Final Report - Corrections Required **Application No. ANEX-24-0007**

Description : Matrix Design Group on behalf of Colorado Springs Equities LLC is submitting a serial annexation petition for seven parcels and Land Use Plan/Rezoning exhibit for a portion of the subdivision known as Rock Creek Mesa.

Document Filename : 224.023-SURV-RCM ANNEX PLAT 7.pdf

ROCK CREEK MESA ADDITION NO. 7

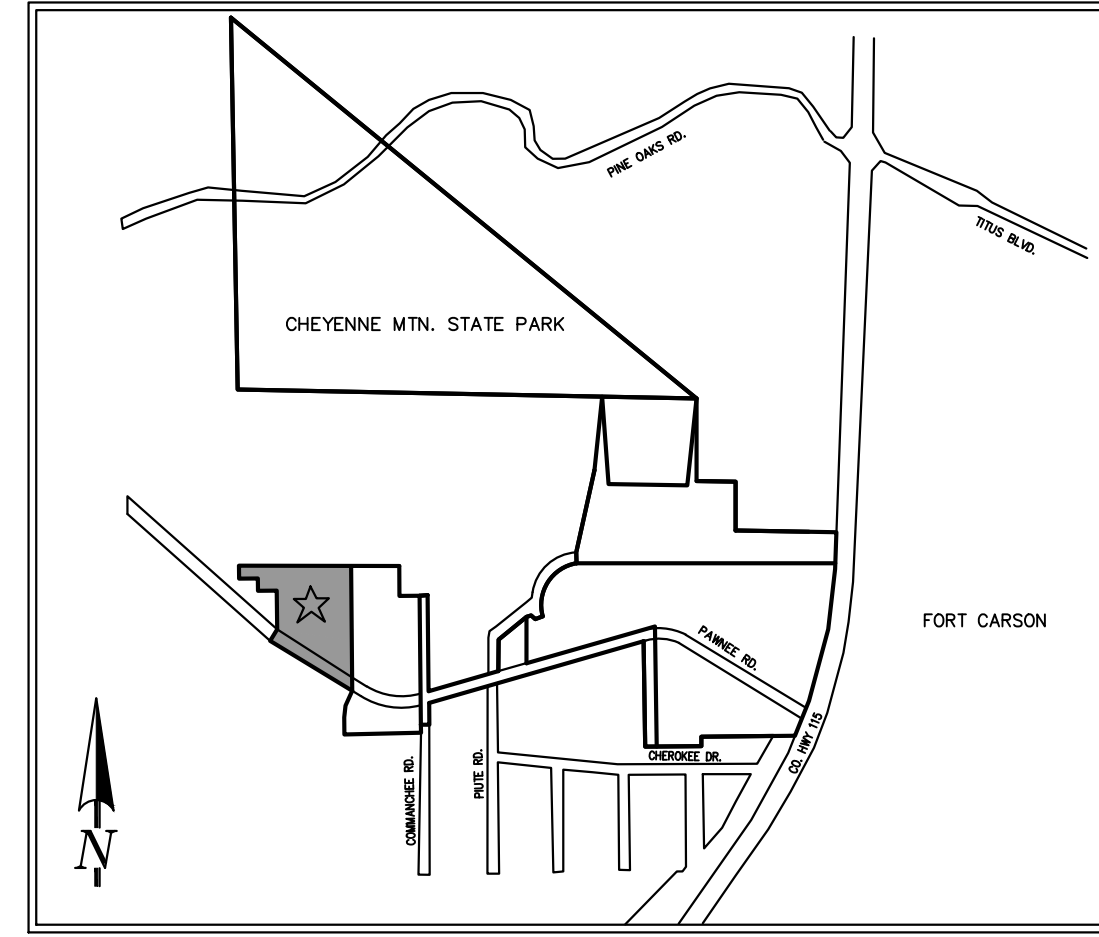
14	224.023-SURV-RCM ANNEX PLAT 7-TITLE	Sara Rivera : City Engineering - SWENT	The FEMA floodplain zone is incorrect. Please update to the correct zone.
2	224.023-SURV-RCM ANNEX PLAT 7-TITLE	Matthew Alcuran : Col Springs Utilities	<p>Please acknowledge the following Water Planning Informational Note: Please refer to the completed Hydraulic Analysis Report completed on November 2, 2023 for HR Green and SSS Education. Conclusions and Requirements: **Modeled fire flows are 2100 to 2200 GPM. No fire flow requirement was provided. **Either alternative presented in this report are acceptable. **Since all pressures are below 170 psi, PVC is acceptable.</p>
3		Matthew Alcuran : Col Springs	Utility Comments (electric, gas, water, wastewater)

8	224.023-SURV-RCM ANNEX PLAT 7-TITLE	Matthew Alcuran : Col Springs Utilities	Please respond to LBS comment: Have reviewed and entered geometry into FIMS. "Please add detail to the Point of Beginning, such as a tie to a parcel or aliquot corner."
15	224.023-SURV-RCM ANNEX PLAT 7-TITLE	Gabe Sevigny : Planning	Update to ANEX-24-0007 on each sheet
18	224.023-SURV-RCM ANNEX PLAT 7-TITLE	Cory Sharp : Planning	Please update 3, 4 & 5 to the following contiguity statement: contiguity statement: Total Perimeter of the Area for Annexation: 2,407.63' One-Fourth (1/4th) of the Total Perimeter: 601.91' (25.00%) Perimeter of the Area Contiguous to the Existing City Limits: 665.86' (27.66%)
19	224.023-SURV-RCM ANNEX PLAT 7-TITLE	Cory Sharp : Planning	Please add the area at the end of the legal description
20	224.023-SURV-RCM ANNEX PLAT 7-TITLE	Cory Sharp : Planning	Please add quotations around the plat name "Rock Creek Mesa Addition No. 7"

ROCK CREEK MESA ADDITION NO. 7

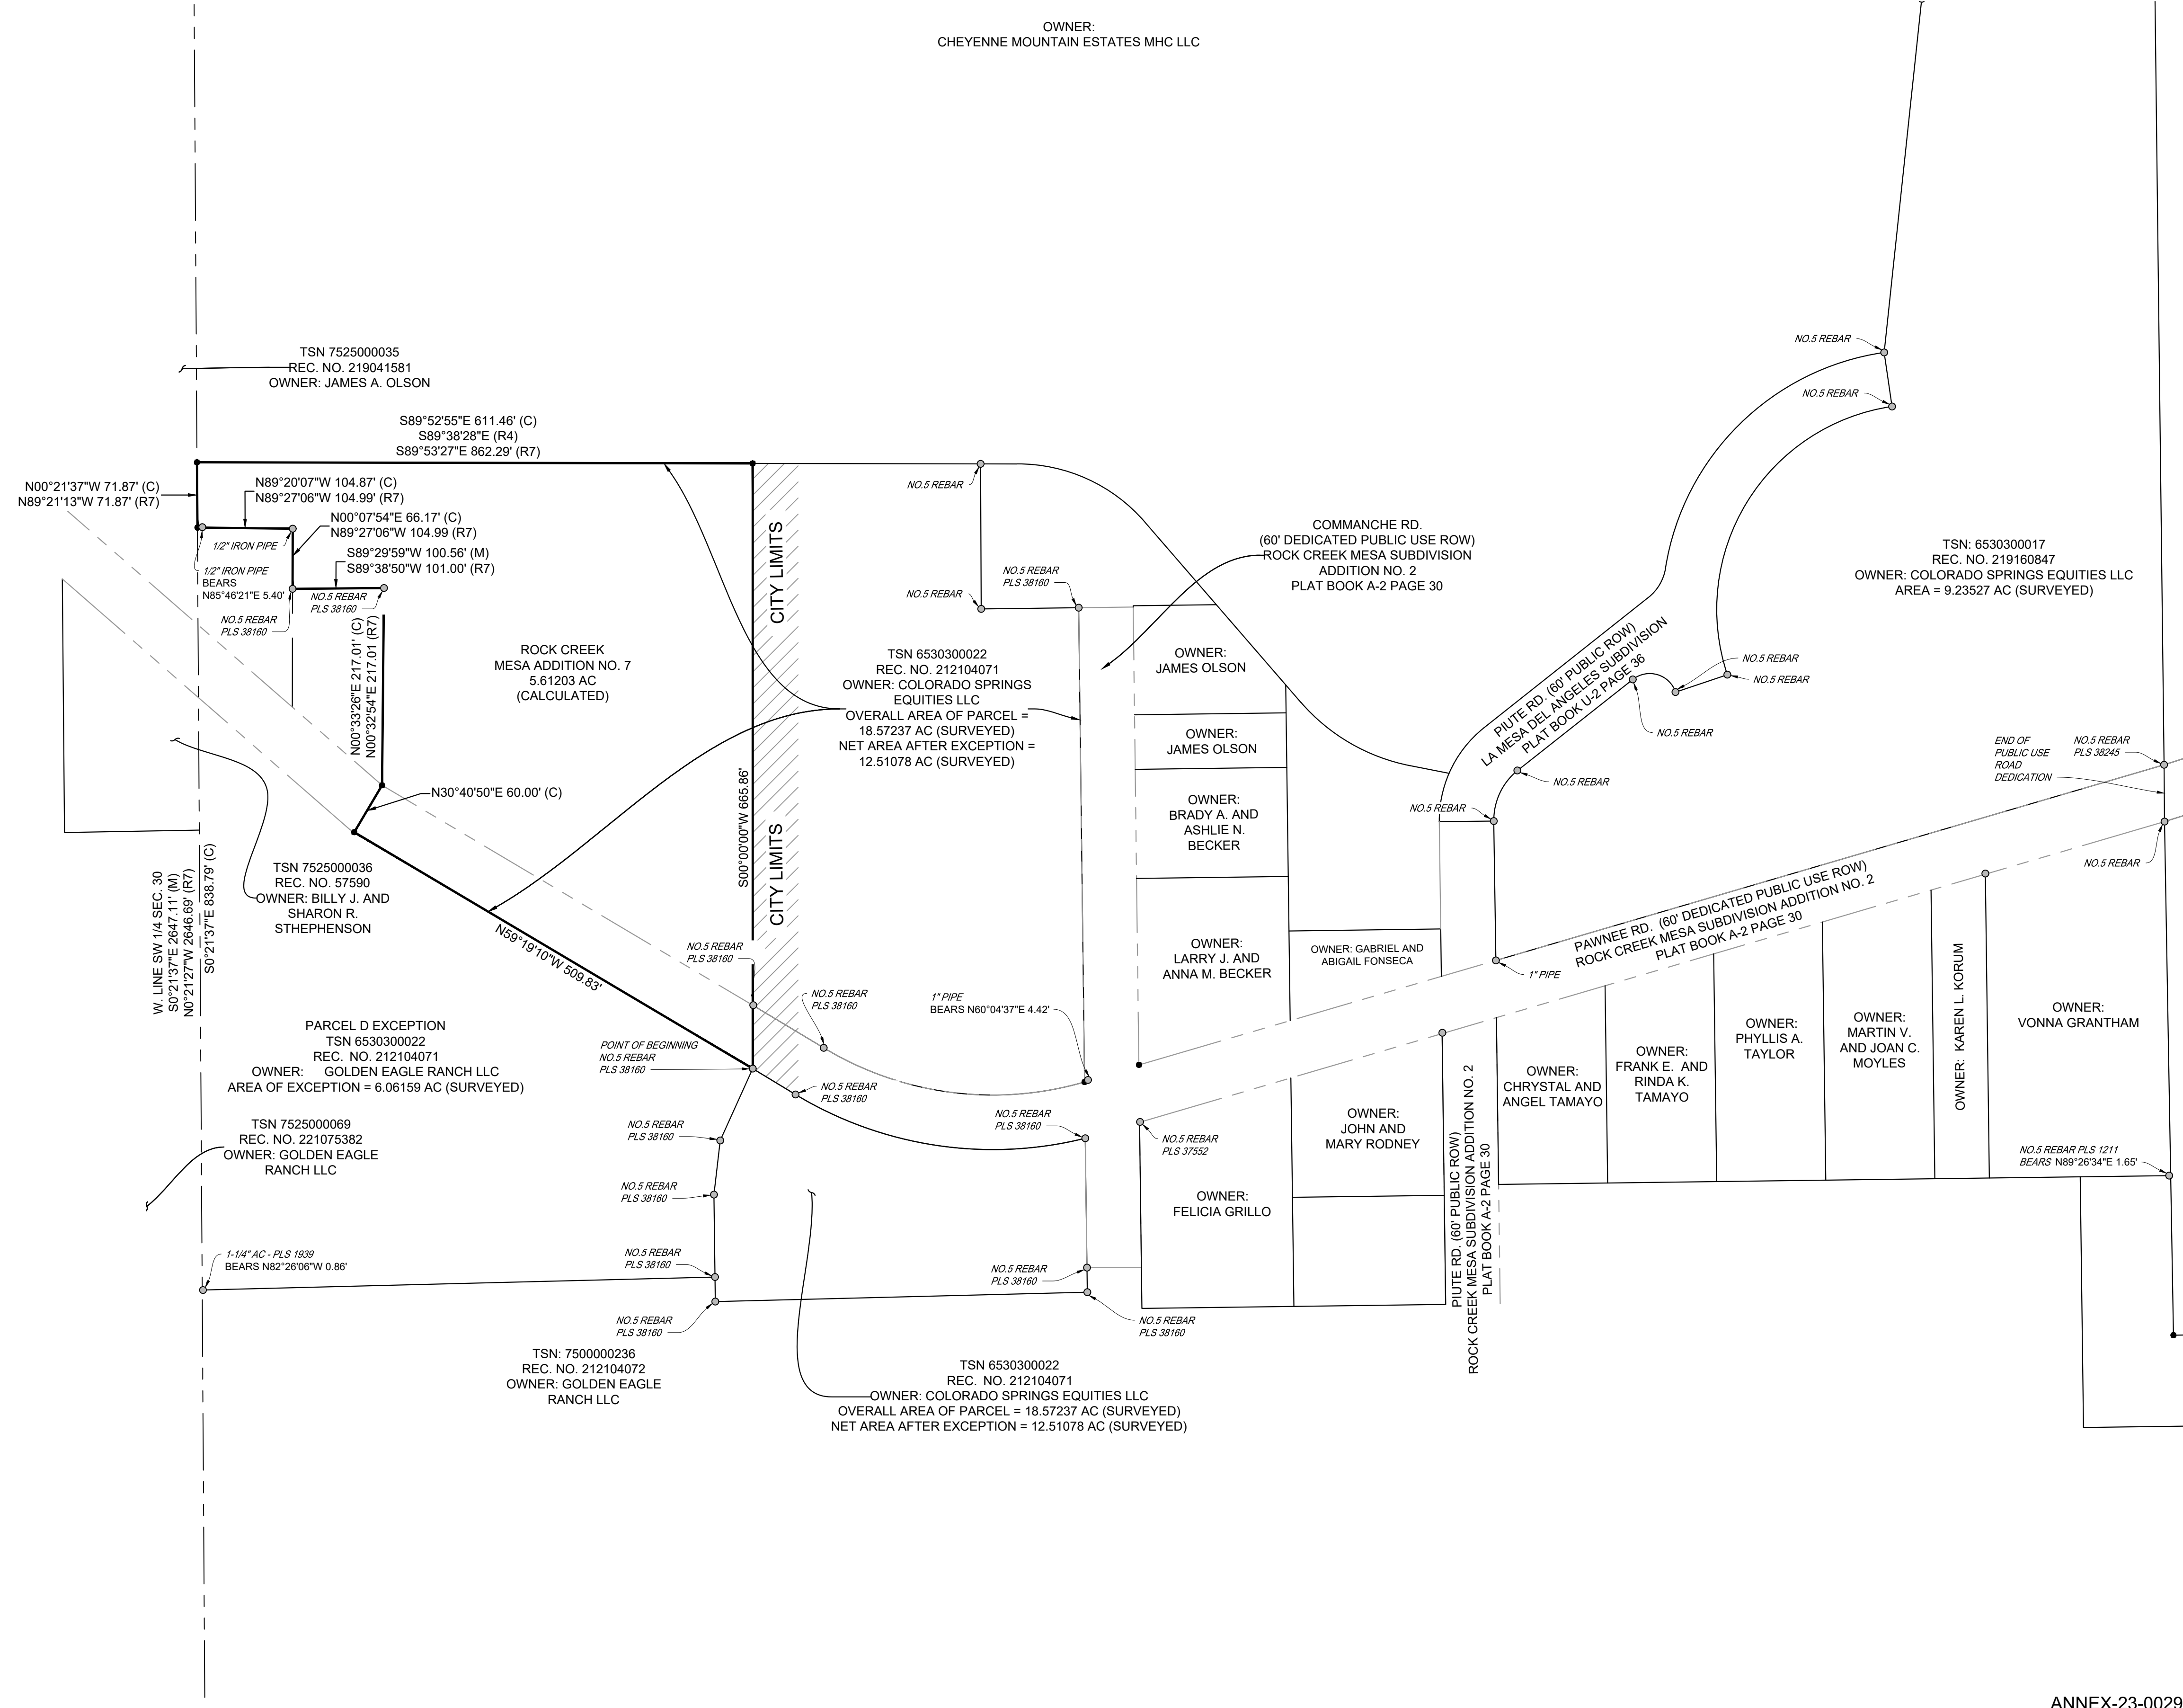
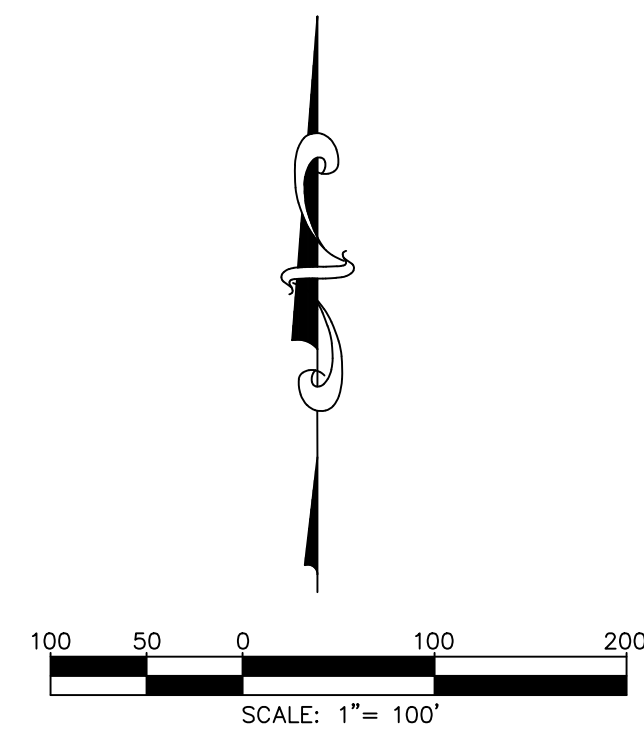
21	224.023-SURV-RCM ANNEX PLAT 7-GRAPHIC 1	Cory Sharp : Planning	Please clearly label the adjacent areas *not a part* for clarity
22	224.023-SURV-RCM ANNEX PLAT 7-GRAPHIC 1	Cory Sharp : Planning	Please clearly depict all of the city limits not just that portion adjacent
23	224.023-SURV-RCM ANNEX PLAT 7-GRAPHIC 1	Cory Sharp : Planning	Please remove the areas from all adjacent parcels
24	224.023-SURV-RCM ANNEX PLAT 7-GRAPHIC 1	Cory Sharp : Planning	Please add labels for the adjacent additions

Comment ID	Page Reference	Reviewer : Department	Review Comments
25	224.023-SURV-RCM ANNEX PLAT 7-GRAPHIC 1	Cory Sharp : Planning	Please remove Rock Creek Mesa Addition No. 7
26	224.023-SURV-RCM ANNEX PLAT 7-GRAPHIC 1	Cory Sharp : Planning	It would be helpful to change the text style of the ownership information so that it is clearly informational text
27	224.023-SURV-RCM ANNEX PLAT 7-GRAPHIC 1	Cory Sharp : Planning	Please add (M) and (C) to the legend
28	224.023-SURV-RCM ANNEX PLAT 7-GRAPHIC 1	Cory Sharp : Planning	It would be easier for review if the adjacent areas were a dashed line type please review and adjust accordingly.
29	224.023-SURV-RCM ANNEX PLAT 7-GRAPHIC 1	Cory Sharp : Planning	Informational: Is it possible to provide the planning department a separate exhibit with all 7 proposed annexations depicted and labeled? Only an informational item? Please coordinate with me if any questions.

30	224.023-SURV-RCM ANNEX PLAT 7-GRAPHIC 1	Cory Sharp : Planning	Please depict and label the basis of bearings and add a tie to the point of beginning so all additions can be tied together
